Rezoning Transportation Analysis

Petition Number: 2021-079

General Location Identifier: 15705136

Reviewer: Walta Blackmon, PE

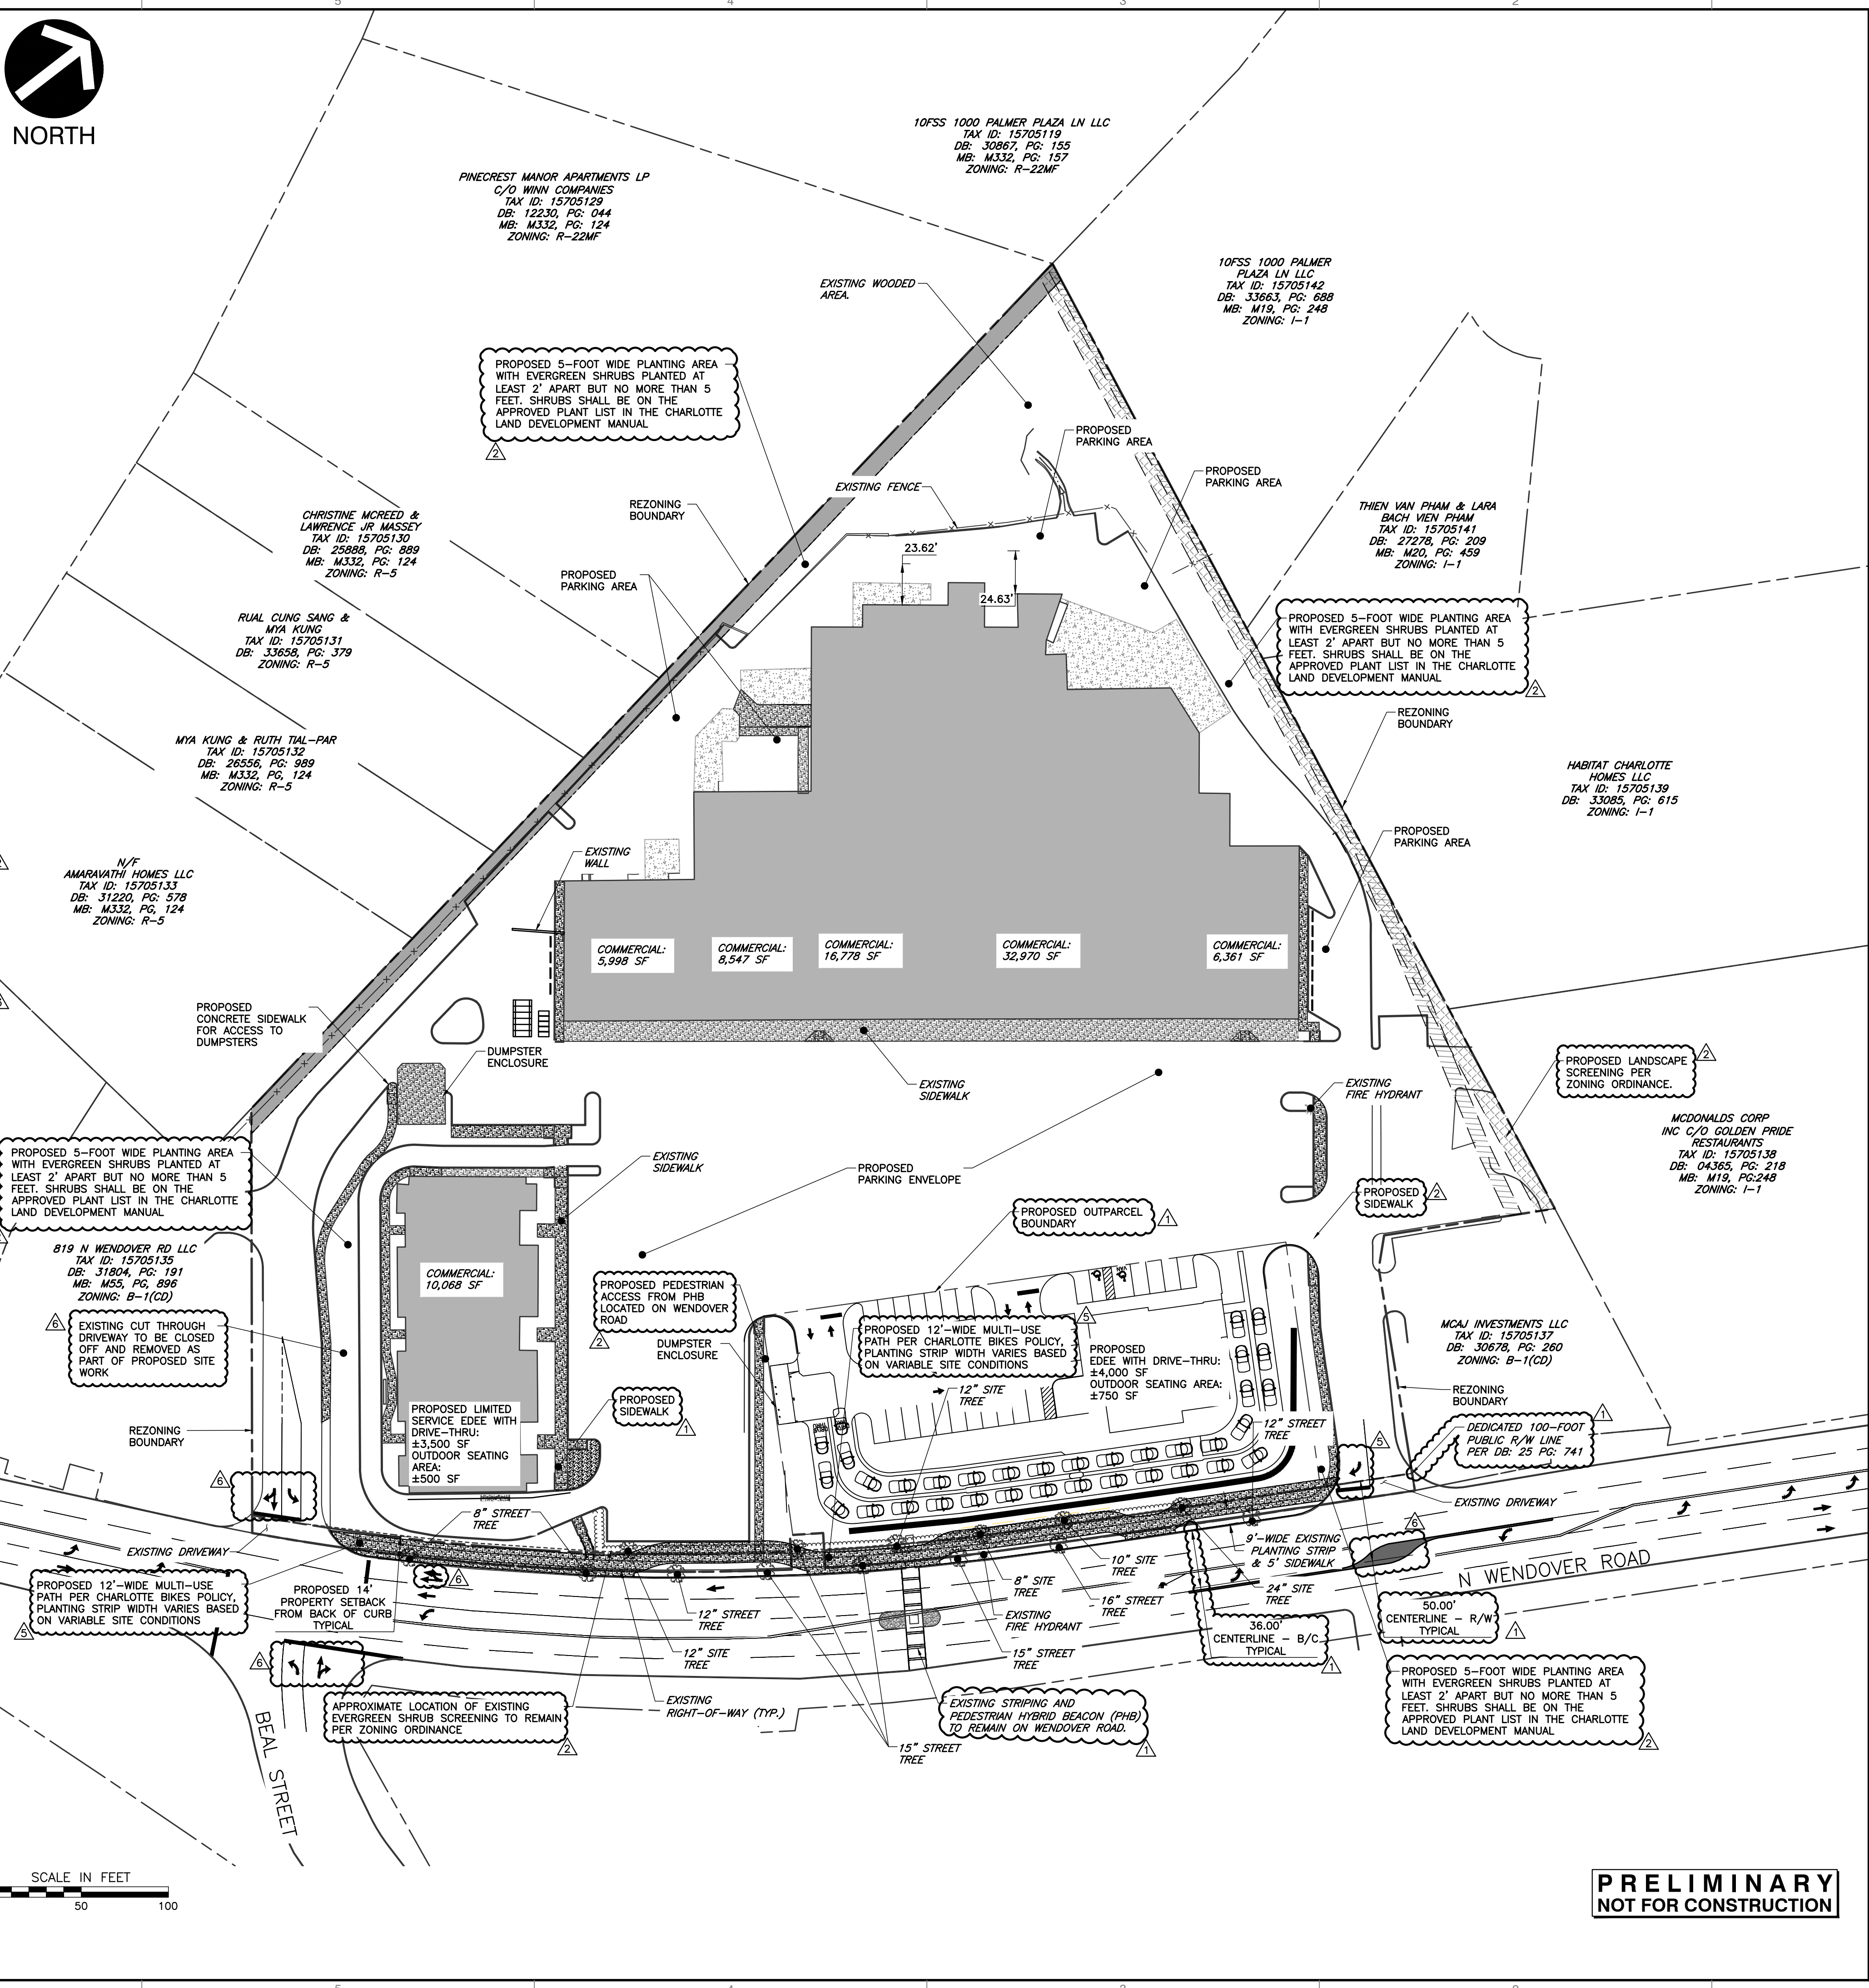
3. **NEW COMMENT (03-16-2022; recommendations based on TIS recommendations)**

Site plan revisions are needed to commit to the installation of a raised concrete median at Access 2 to enforce a directional crossover. CDOT and NCDOT to enforce during the permitting phase. (4/12/2022)
